Re: Camp Agape

This department has reviewed the plan you submitted for the Camp Agape swimming pool to be constructed at 1369 Tyler Dewar Ln, Fuquay Varina. This plan review was conducted in accordance with the current North Carolina Rules Governing Public Swimming Pools (15A NCAC 18A .2500).

Further information is needed regarding the following items for review to continue:

POOL EQUIPMENT ROOM LAYOUT PLAN

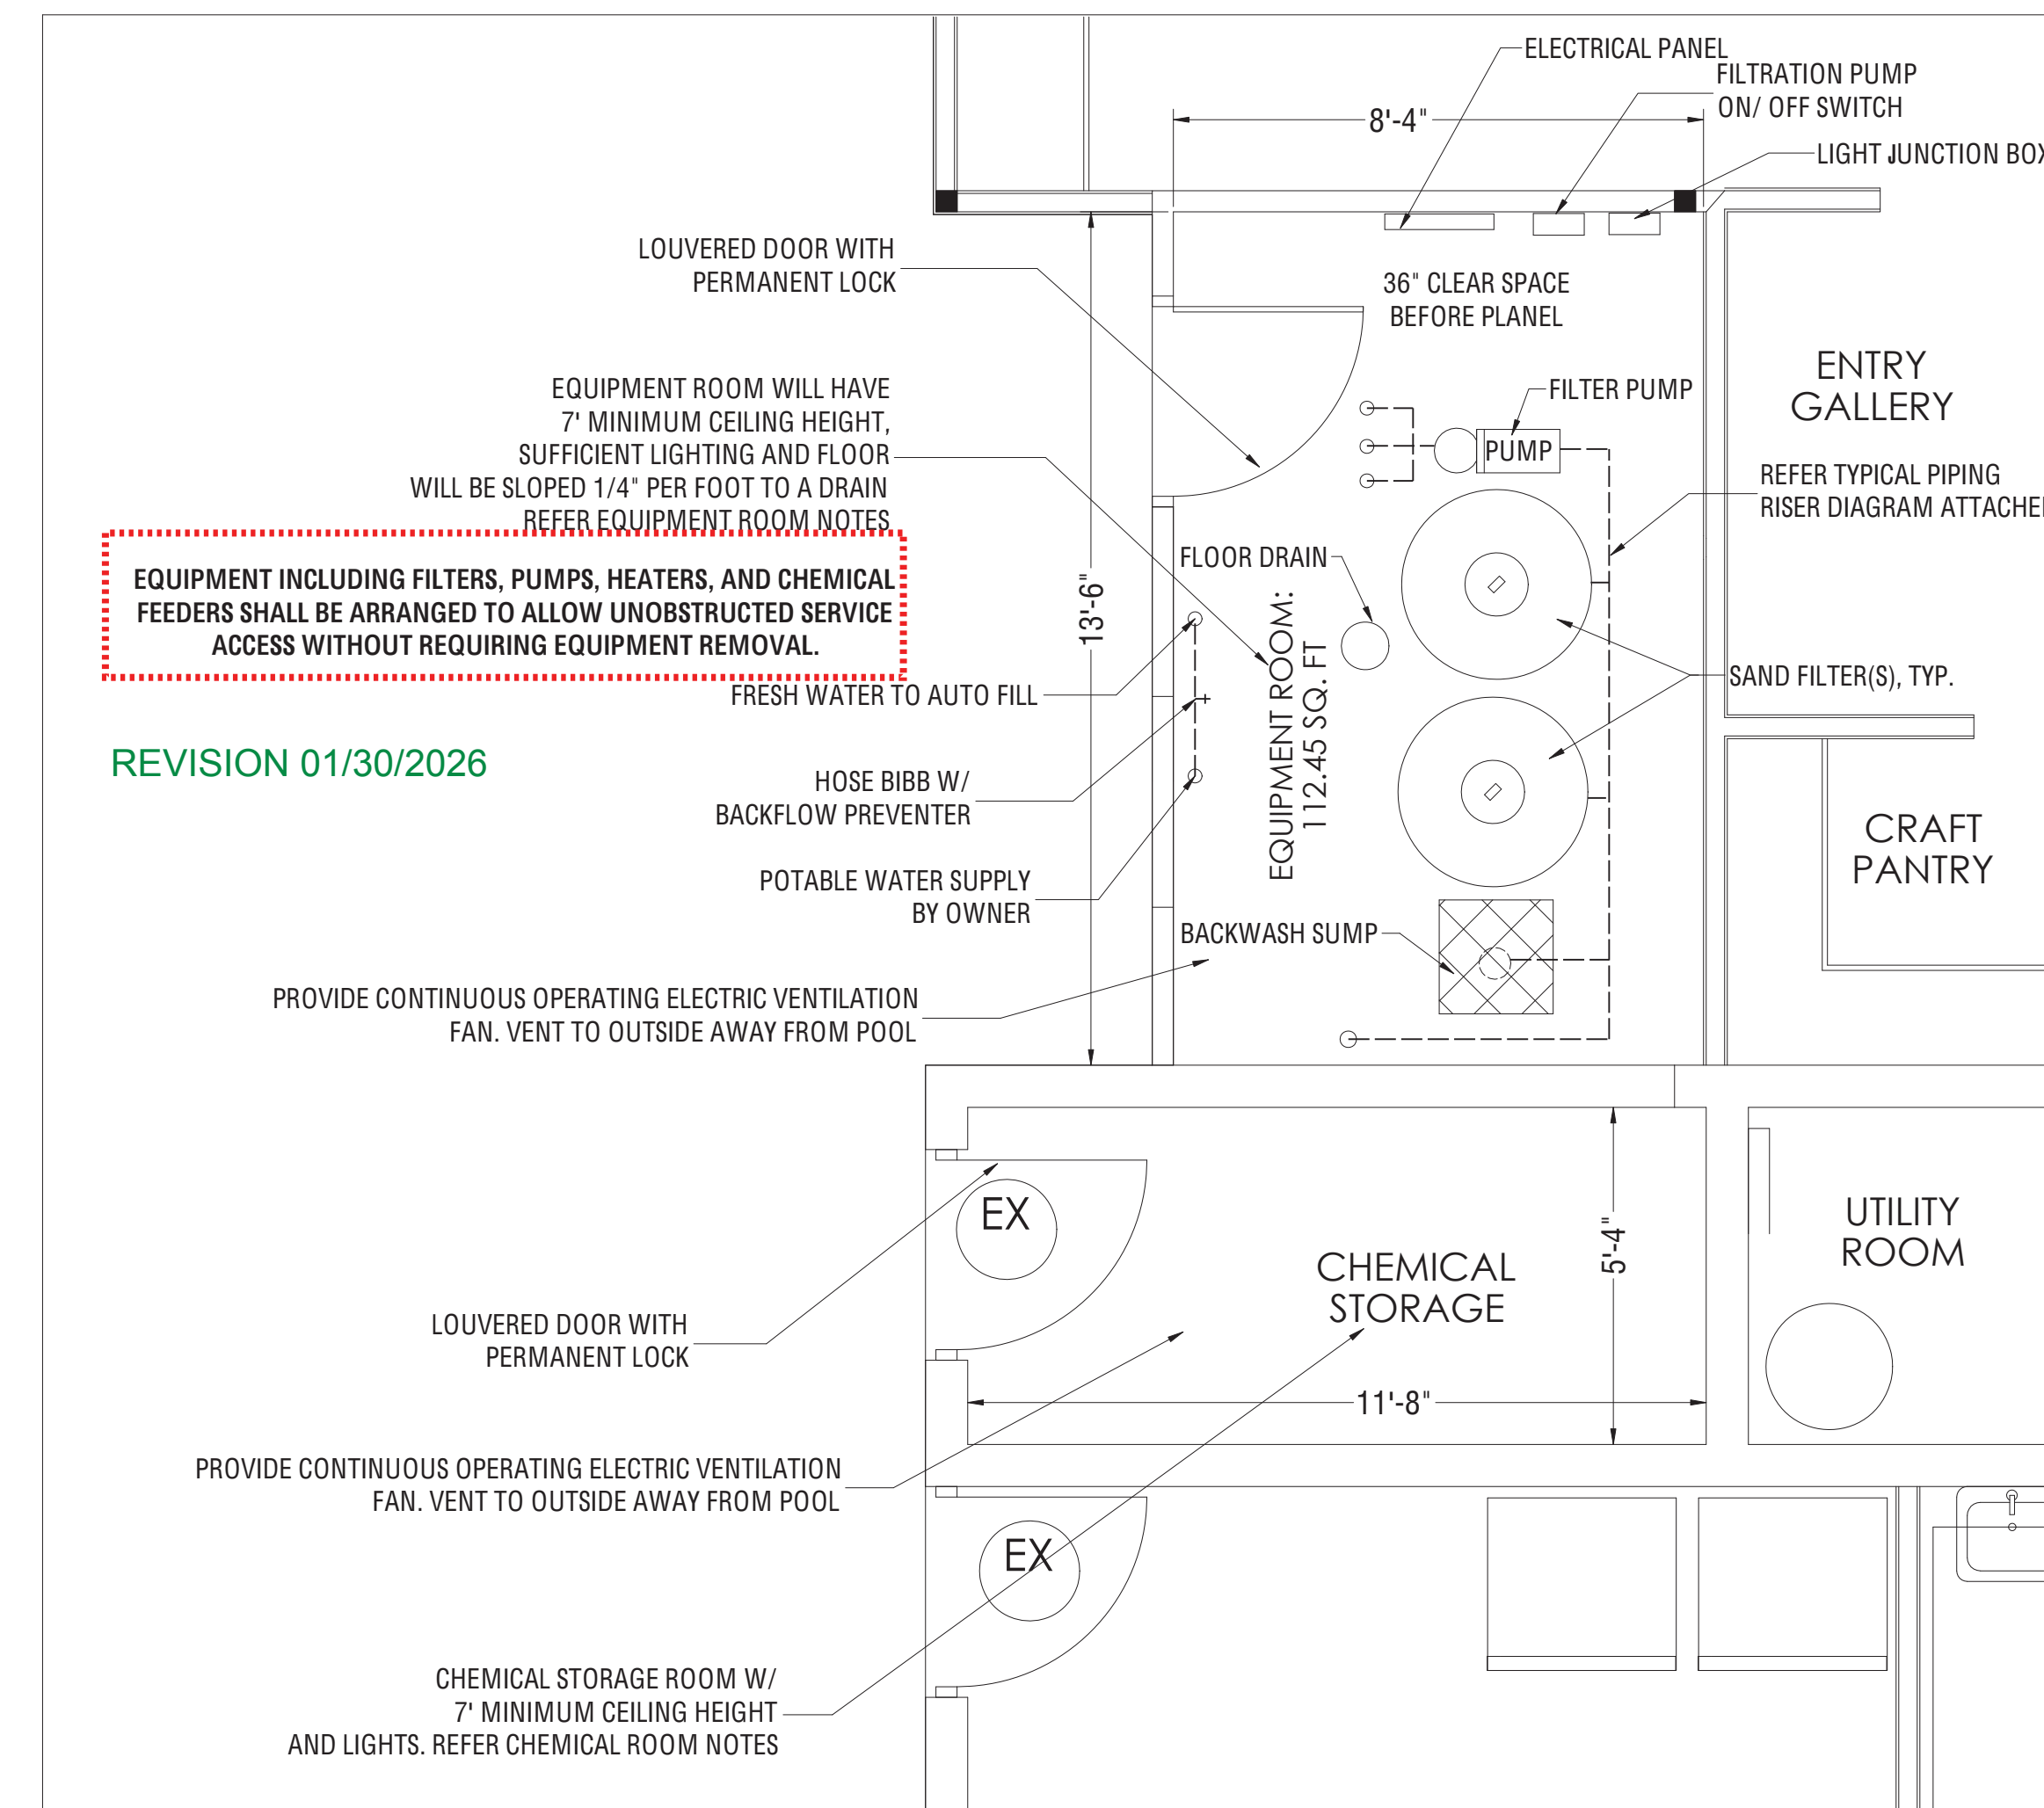
- Layout of equipment in pump room shows piping to be on the wall side of the filters and therefore not allowing for clear access.
- Pool profile section (A-A) shows right angles in pool bottom; no cove or radius shown.

TYPICAL POOL LIGHT, JUNCTION BOX & TRANSFORMER DETAIL (N.T.S)

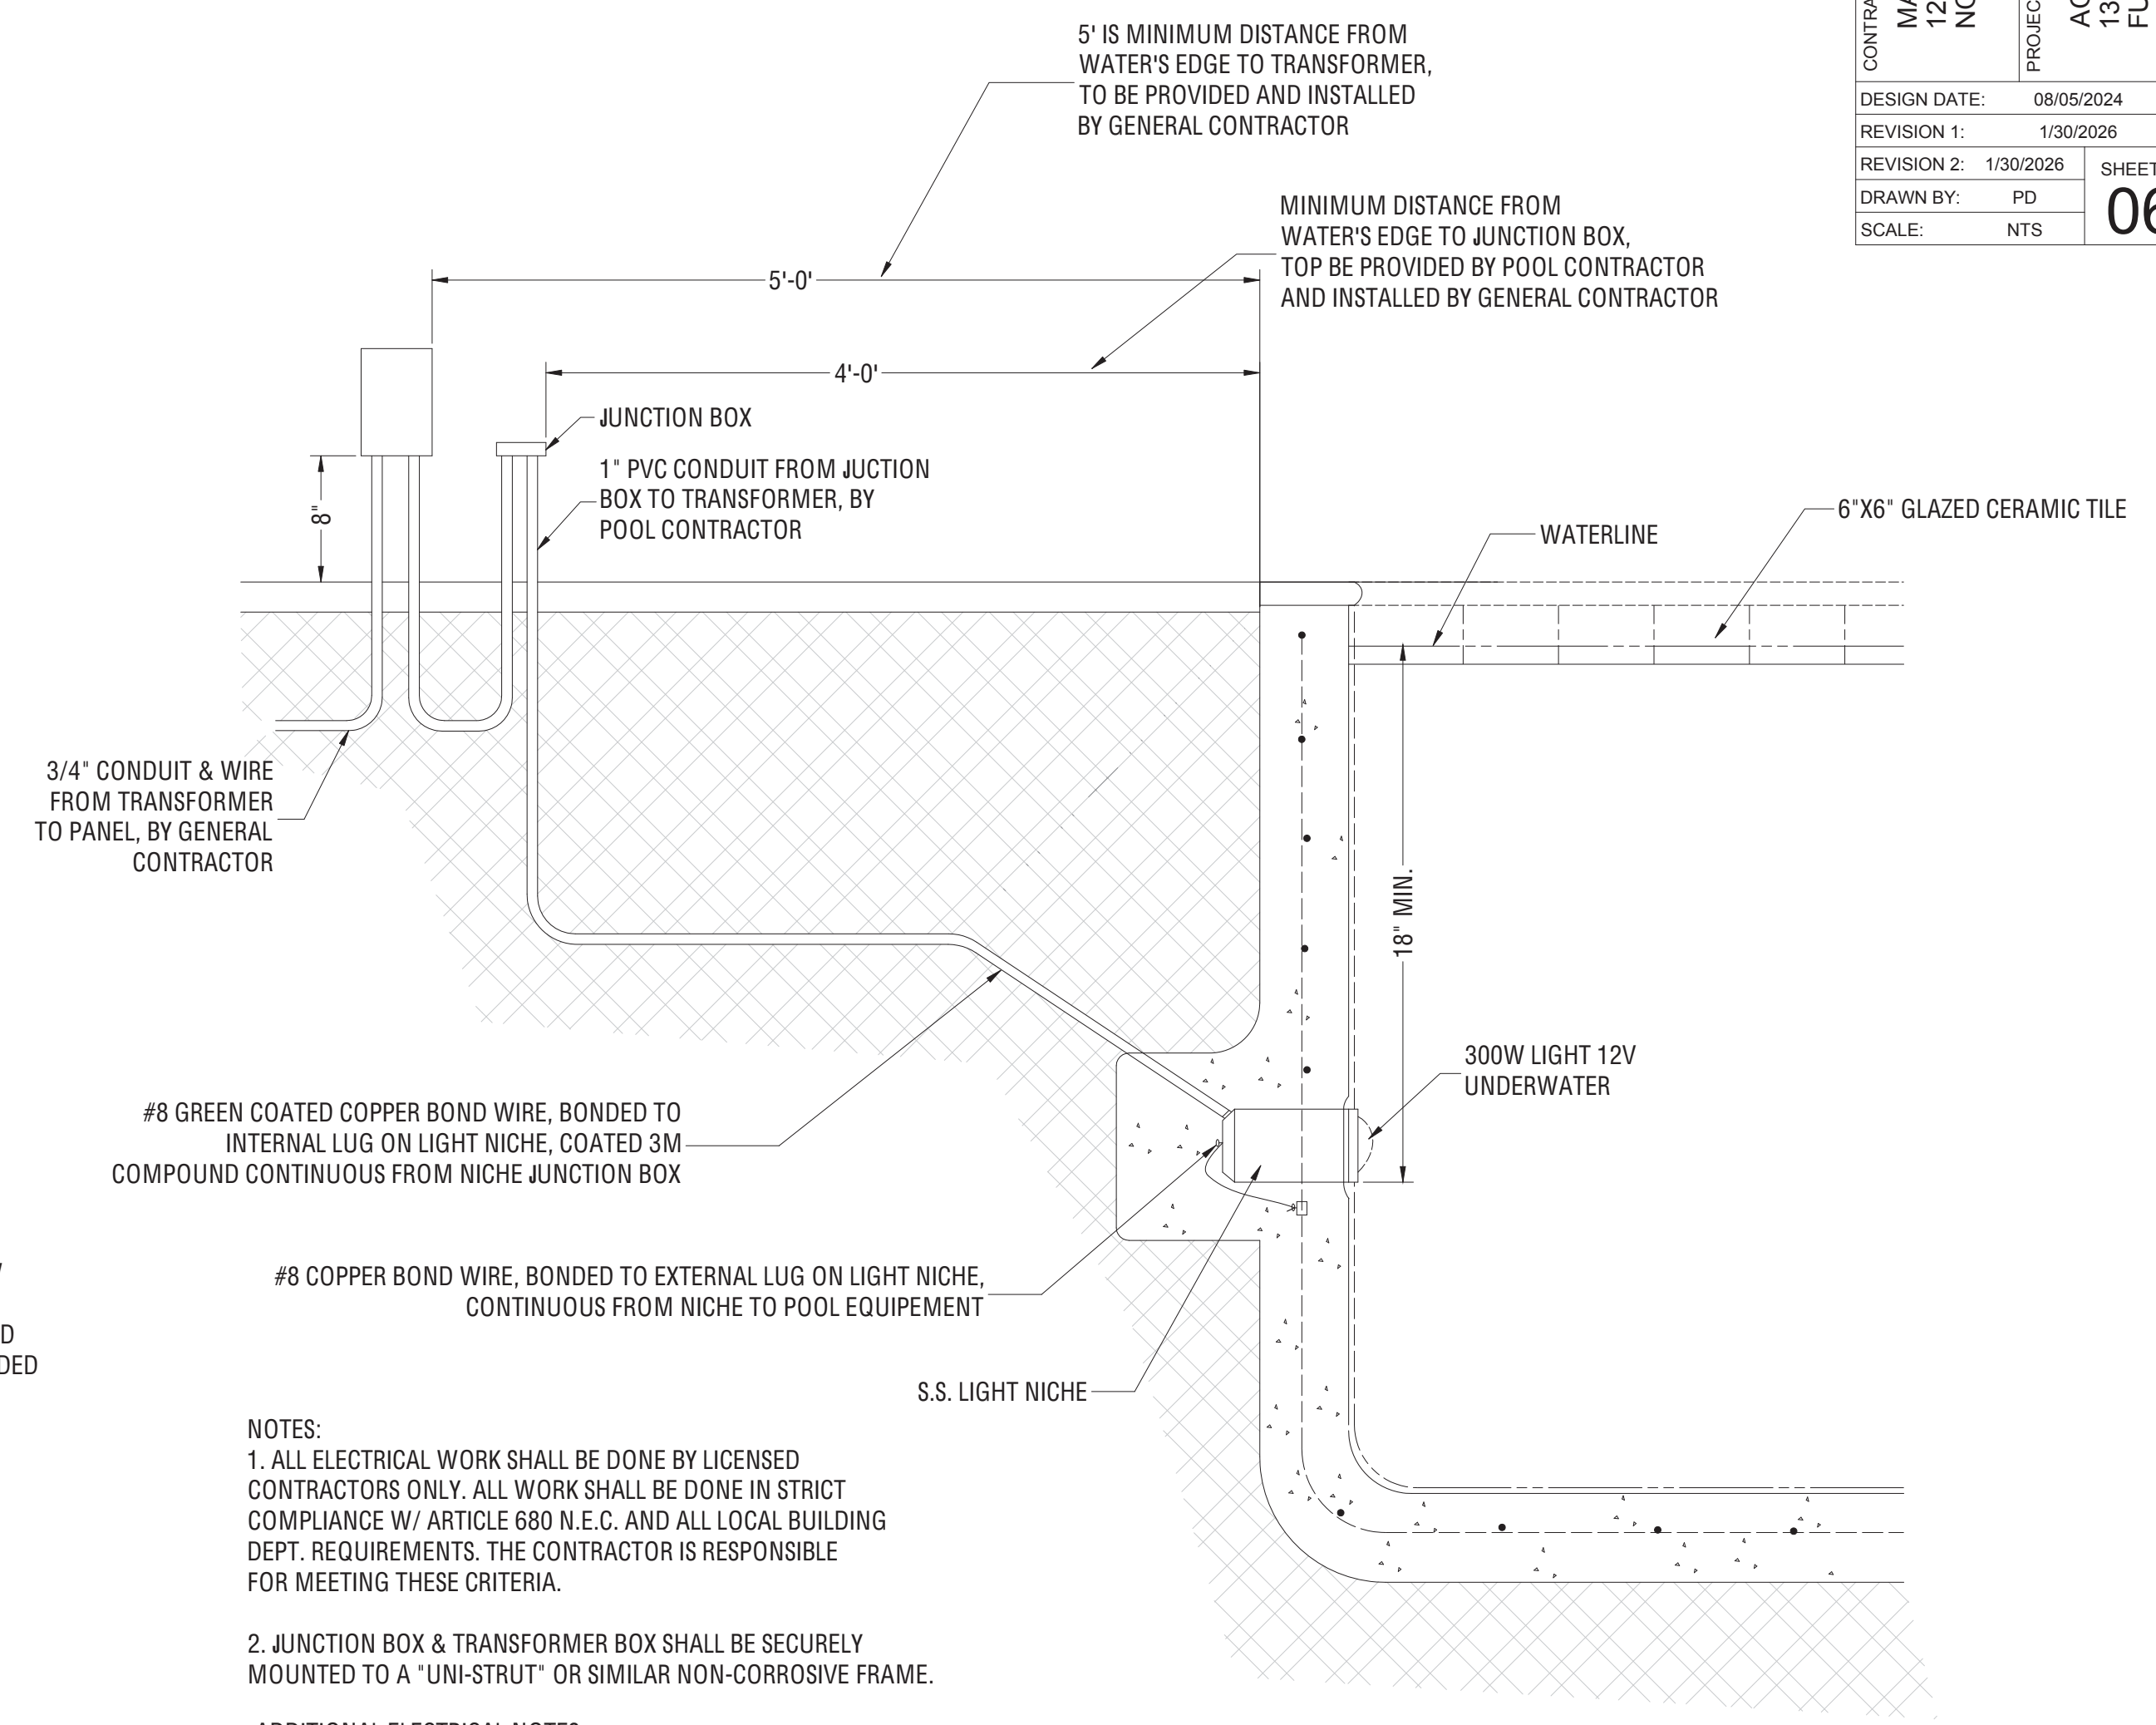
- Clarify nature of slip resistance of pool bottom.
- No clear location provided for light junction boxes.
- No handrail is provided from the deck to the sun shelf.
